Stonestreet Green Solar Project

Planning Inspectorate Reference: EN010135

Deadline 3 - Response to the Examining Authority's Written Questions by CPRE Kent

Illustrative Layout Plan
Sheet 4 of 5

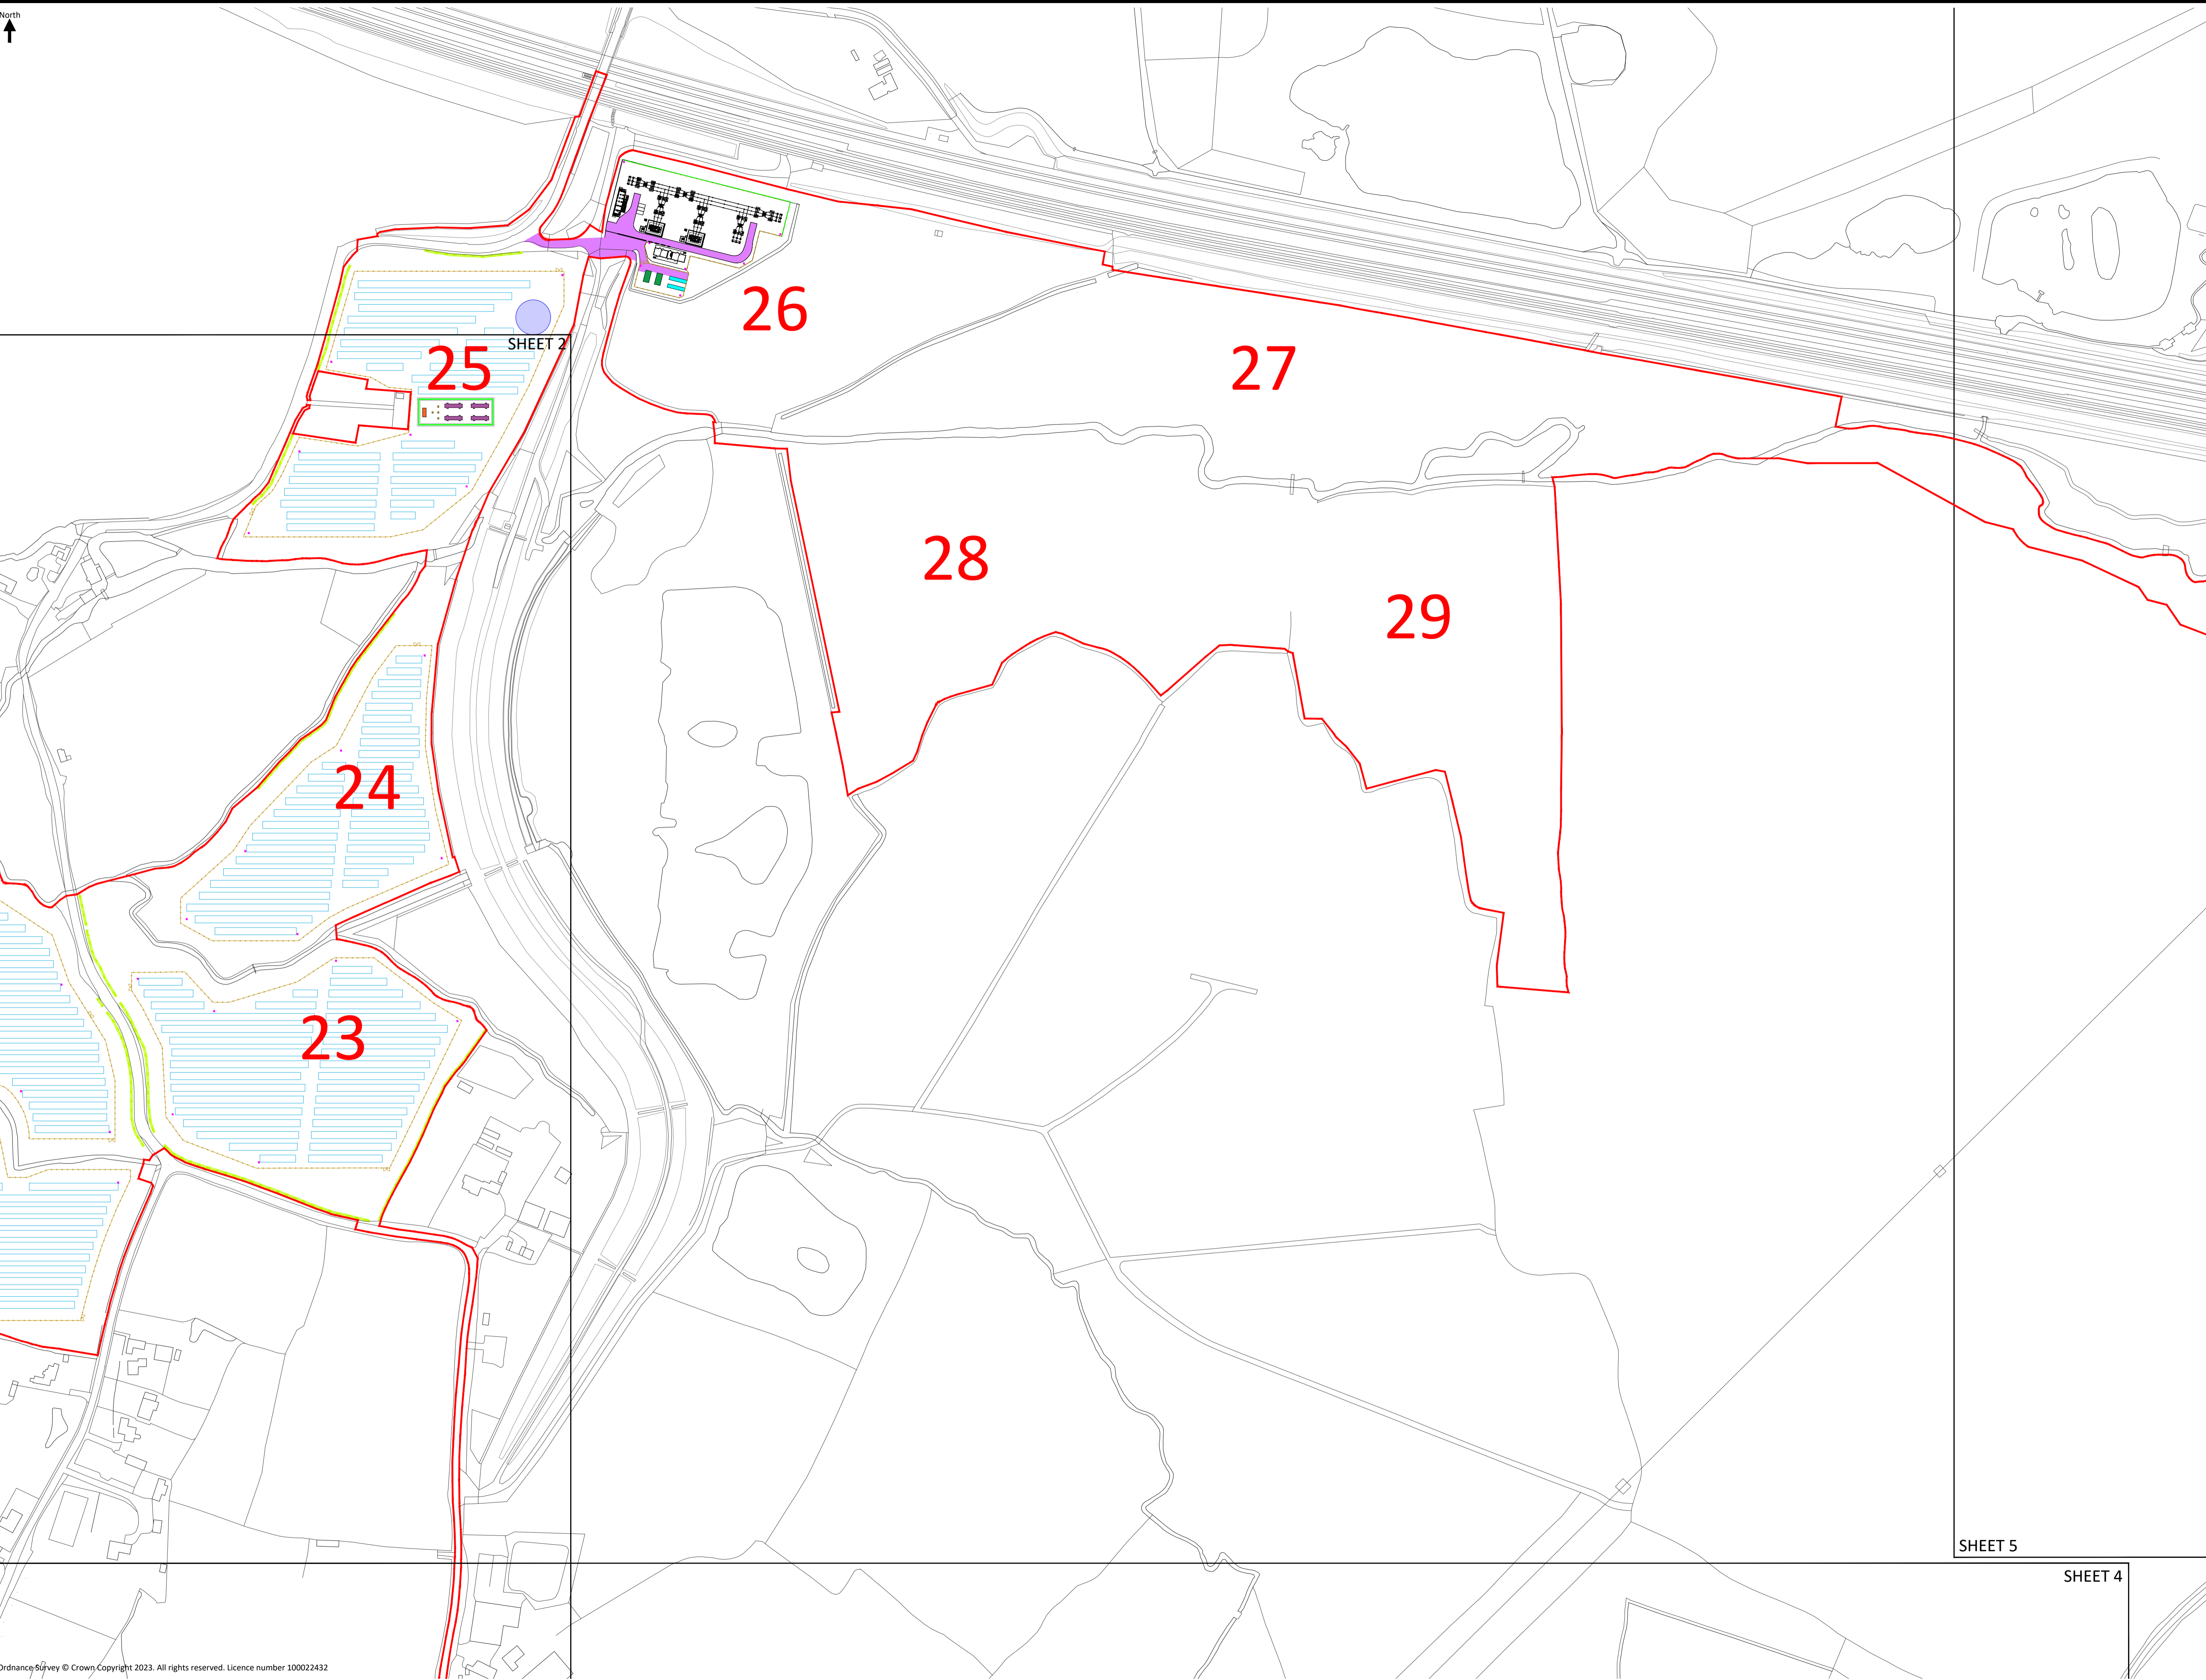
<p>appear to signally focus upon the substantive area of the application though do not hold up when applied to fields 20, 21 and 22. As previously stated, these fields are distinct and separate from the rest of the development, meaning that the siting of solar panels on these fields unnecessarily fragments the development, exacerbating the landscape harm. Siting panels upon these fields also brings the impact of the development much closer to the main residential area of Aldington, has a particular and unique impact upon the enjoyment of the local PROWs, has a particular impact upon local heritage assets and increases the loss of BMV.</p> <p>NPS EN-3 sets out the key siting considerations that need to be taken into account with respect to site selection. Among other considerations, these include proximity to dwellings (addressing visual amenity and glint), land type (favouring poorer-quality or previously developed land), site accessibility, public rights of way (minimising visual impact) and potential visual and landscape impacts, especially within National Landscapes and their settings.</p> <p>In view of these policy requirements and the very particular impact of fields 20, 21 and 22, it is CPRE Kent's view that it would assist the examination to understand further why an assessment of an alternative scheme that did not include these fields has not been undertaken during the site selection process. While we have seen the applicant's assertion that they need these fields to maximise generating capacity, surely this assertion needs to be properly quantified in terms of benefits versus impacts?</p> <p>Overall, CPRE Kent maintains that the removal of panels from fields 20, 21 and 22 would significantly reduce the impact of the proposal and that this should be an option being considered as an improvement upon the submitted scheme. In this regard, we note that the recent approval of the West Burton Solar Project dealt with a similar issue, with the approved DCO having been amended to remove a similarly contentious parcel of land.</p>
